Local Policing Support Team

Your Ref: LU/60/22/PL

RE: 27 Clifton Road Littlehampton BN17 5TE

Thank you for your correspondence of the 8th of March 2022, advising me of a planning application for change of use (regularisation and part retrospective) from 11 bed HMO (Sui Generis) to a 20 bed HMO & 2 No dwellings (net gain of 1 No dwelling). This site is in CIL Zone 4 at the above location, for which you seek advice from a crime prevention viewpoint.

Project 27 CLIFTON ROAD, LITTLEHAMPTON BN17 5TE		
Title PROPOSED REAR AND SIDE ELEVATION		
Drawn By DH	Checked ASPIRE	Date JAN 22
Drawing Number 1714-16	Revision -	Scale 1:100@A3
Client -

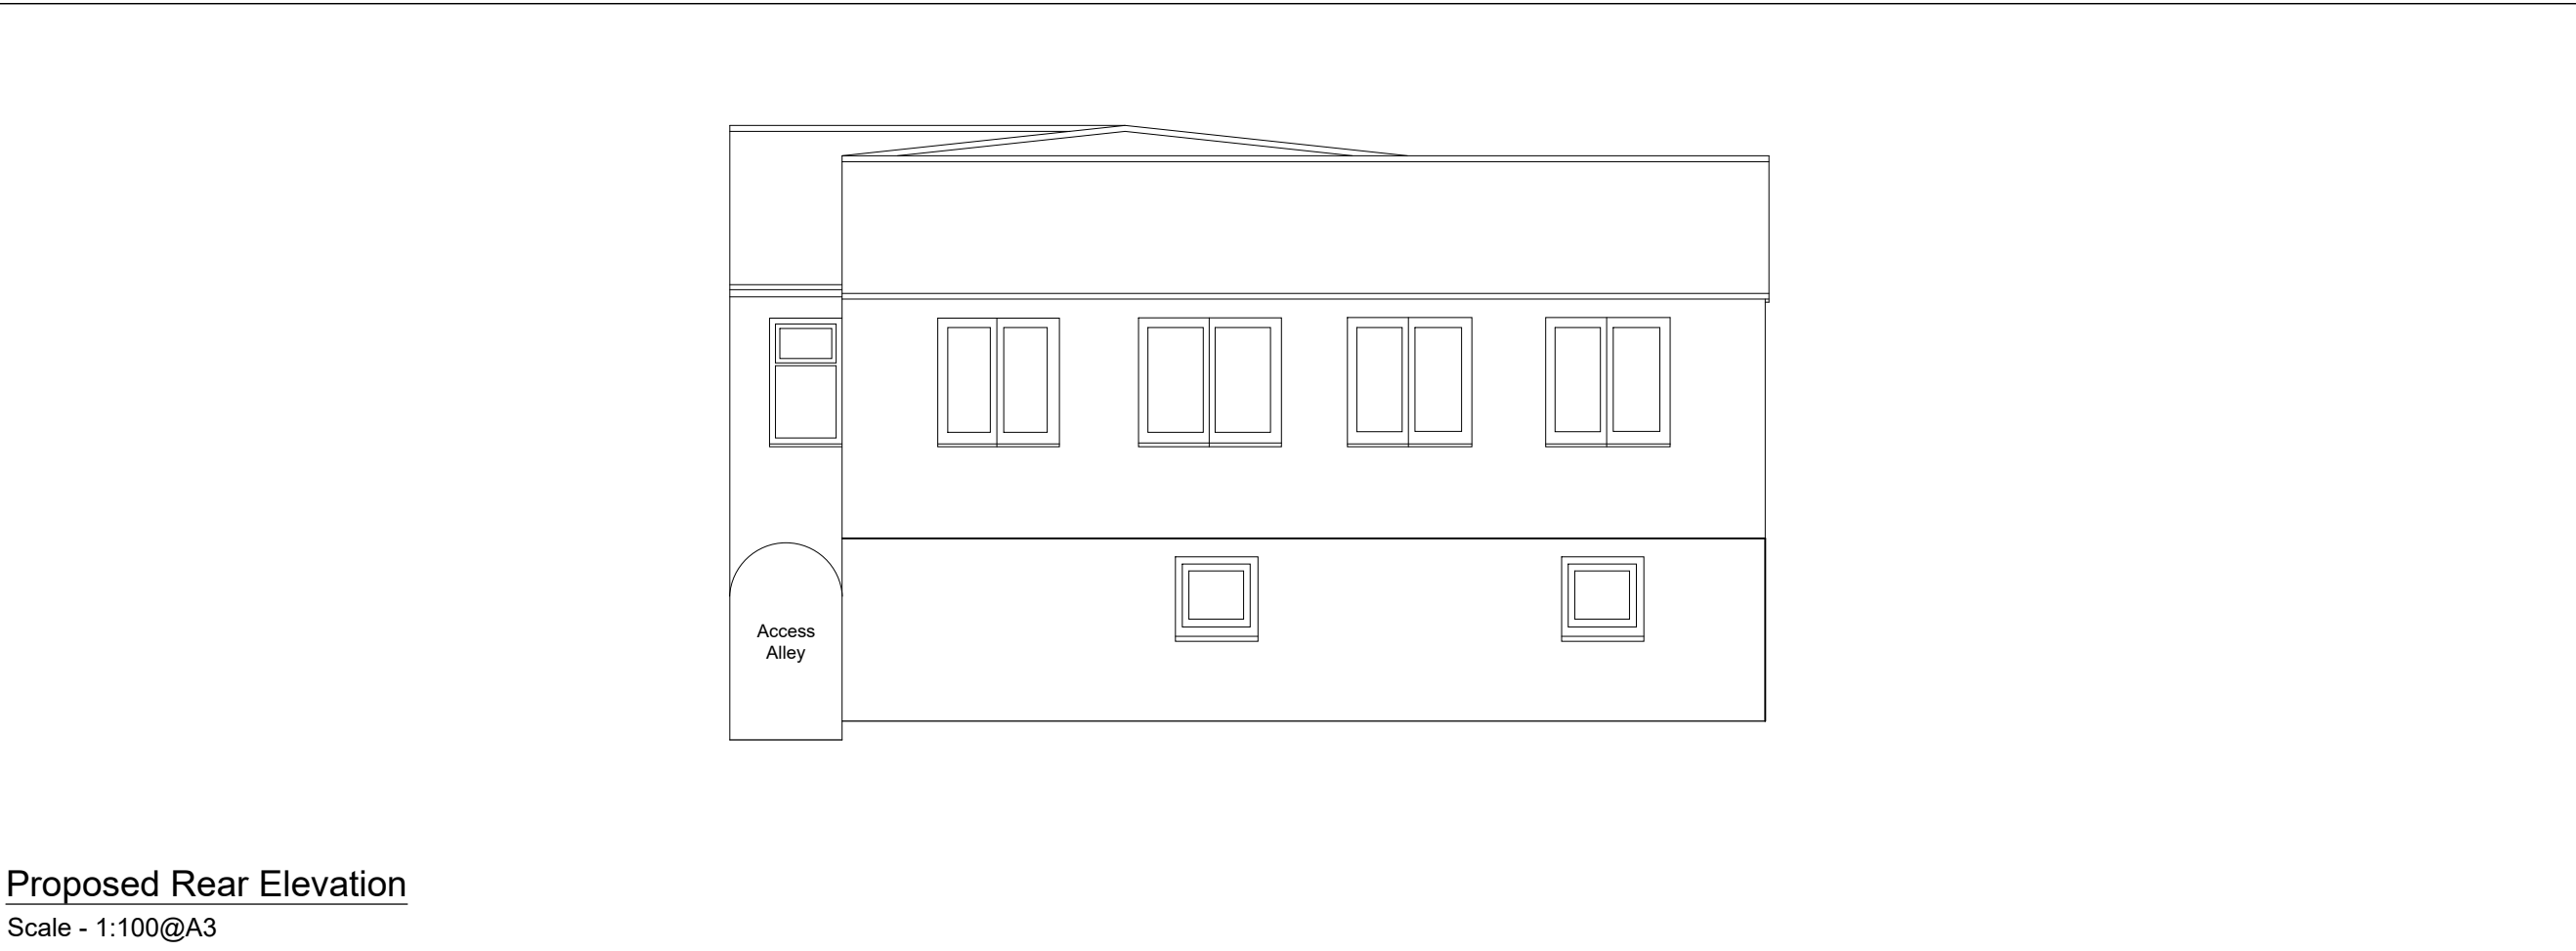
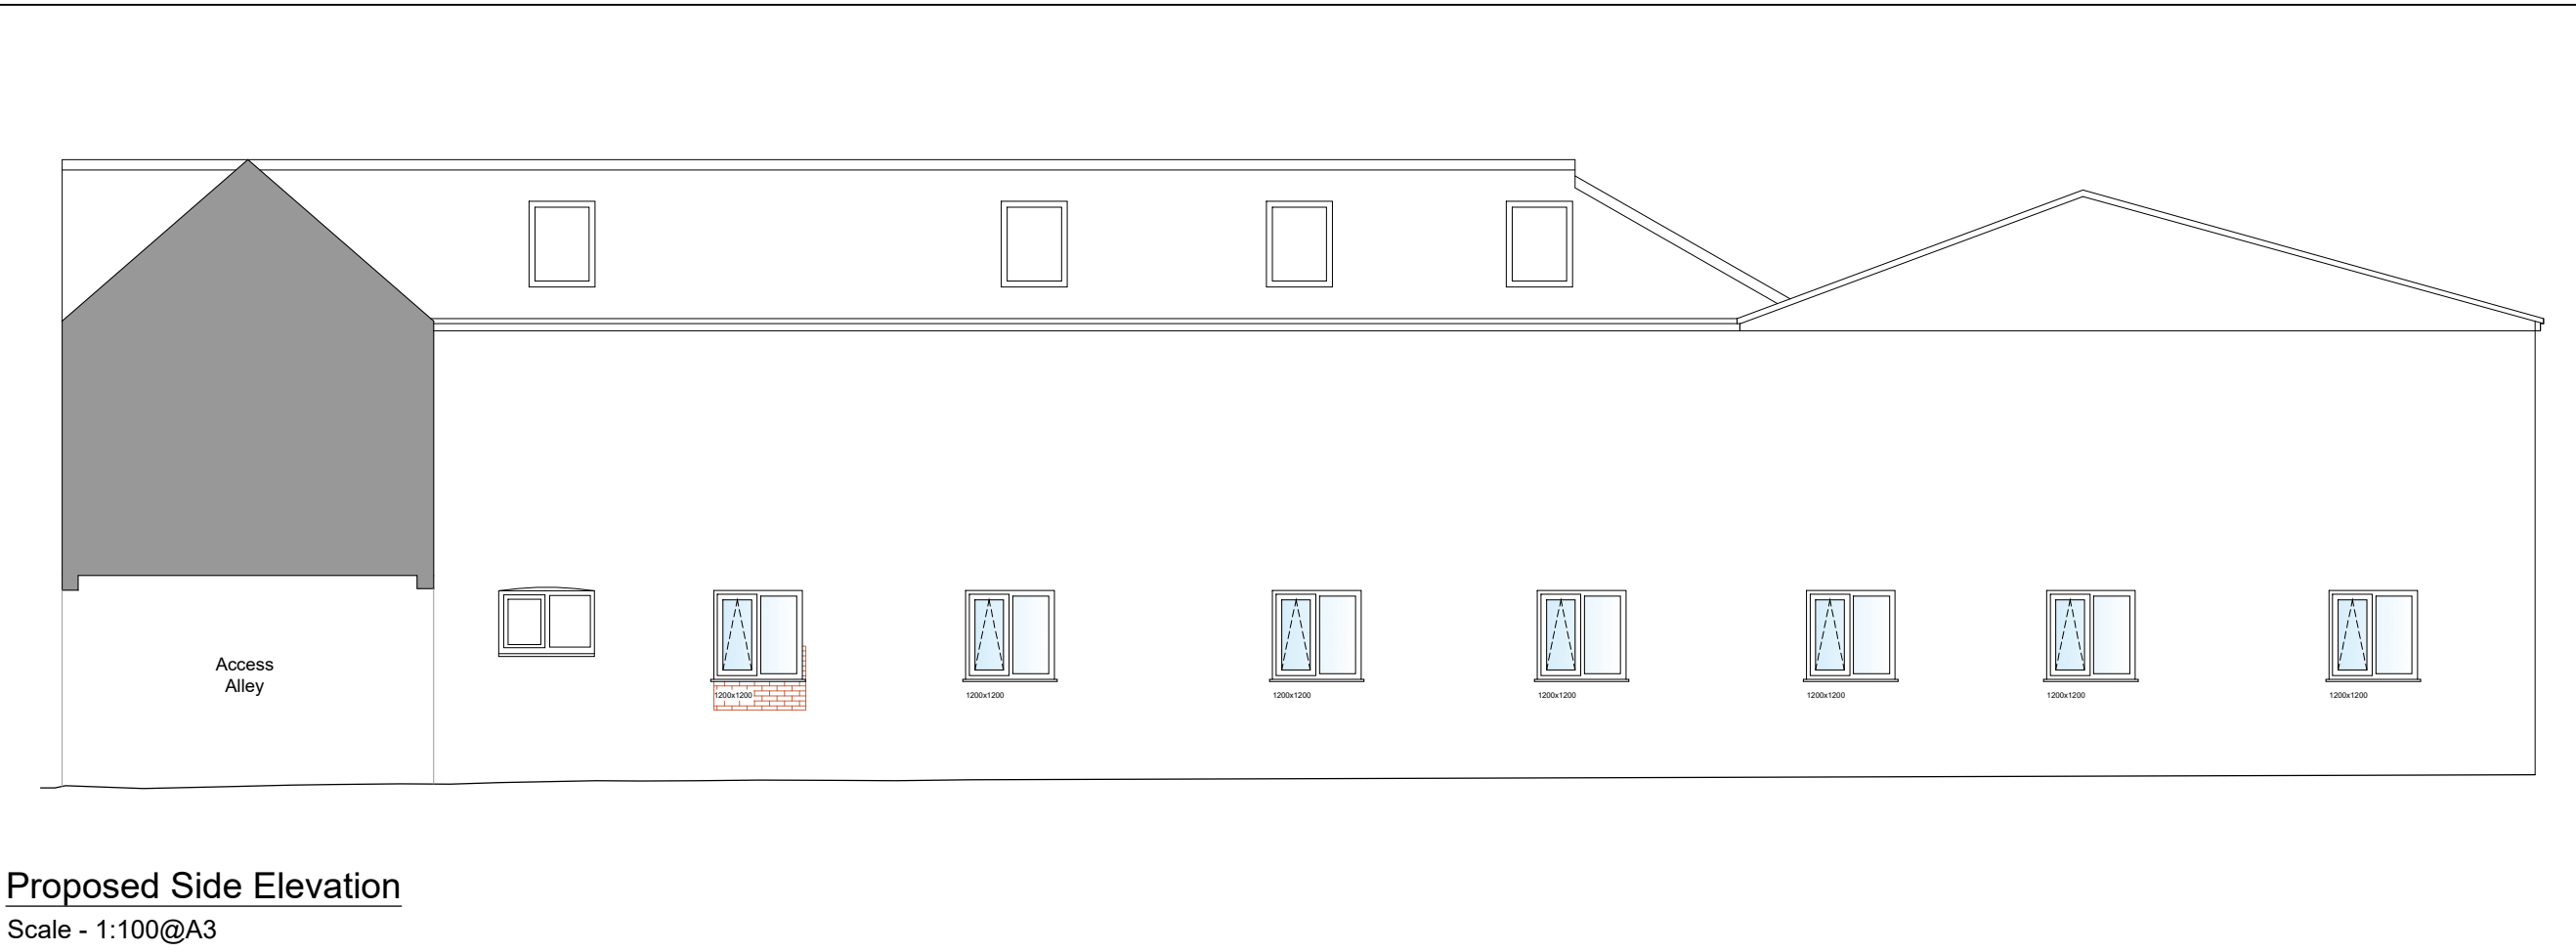
With regards to the communal terrace which can be used by all residents - in order to safeguard the amenity of the surrounding residential properties use of this area late into the night must be stringently managed to ensure excessive noise is kept to a minimum.
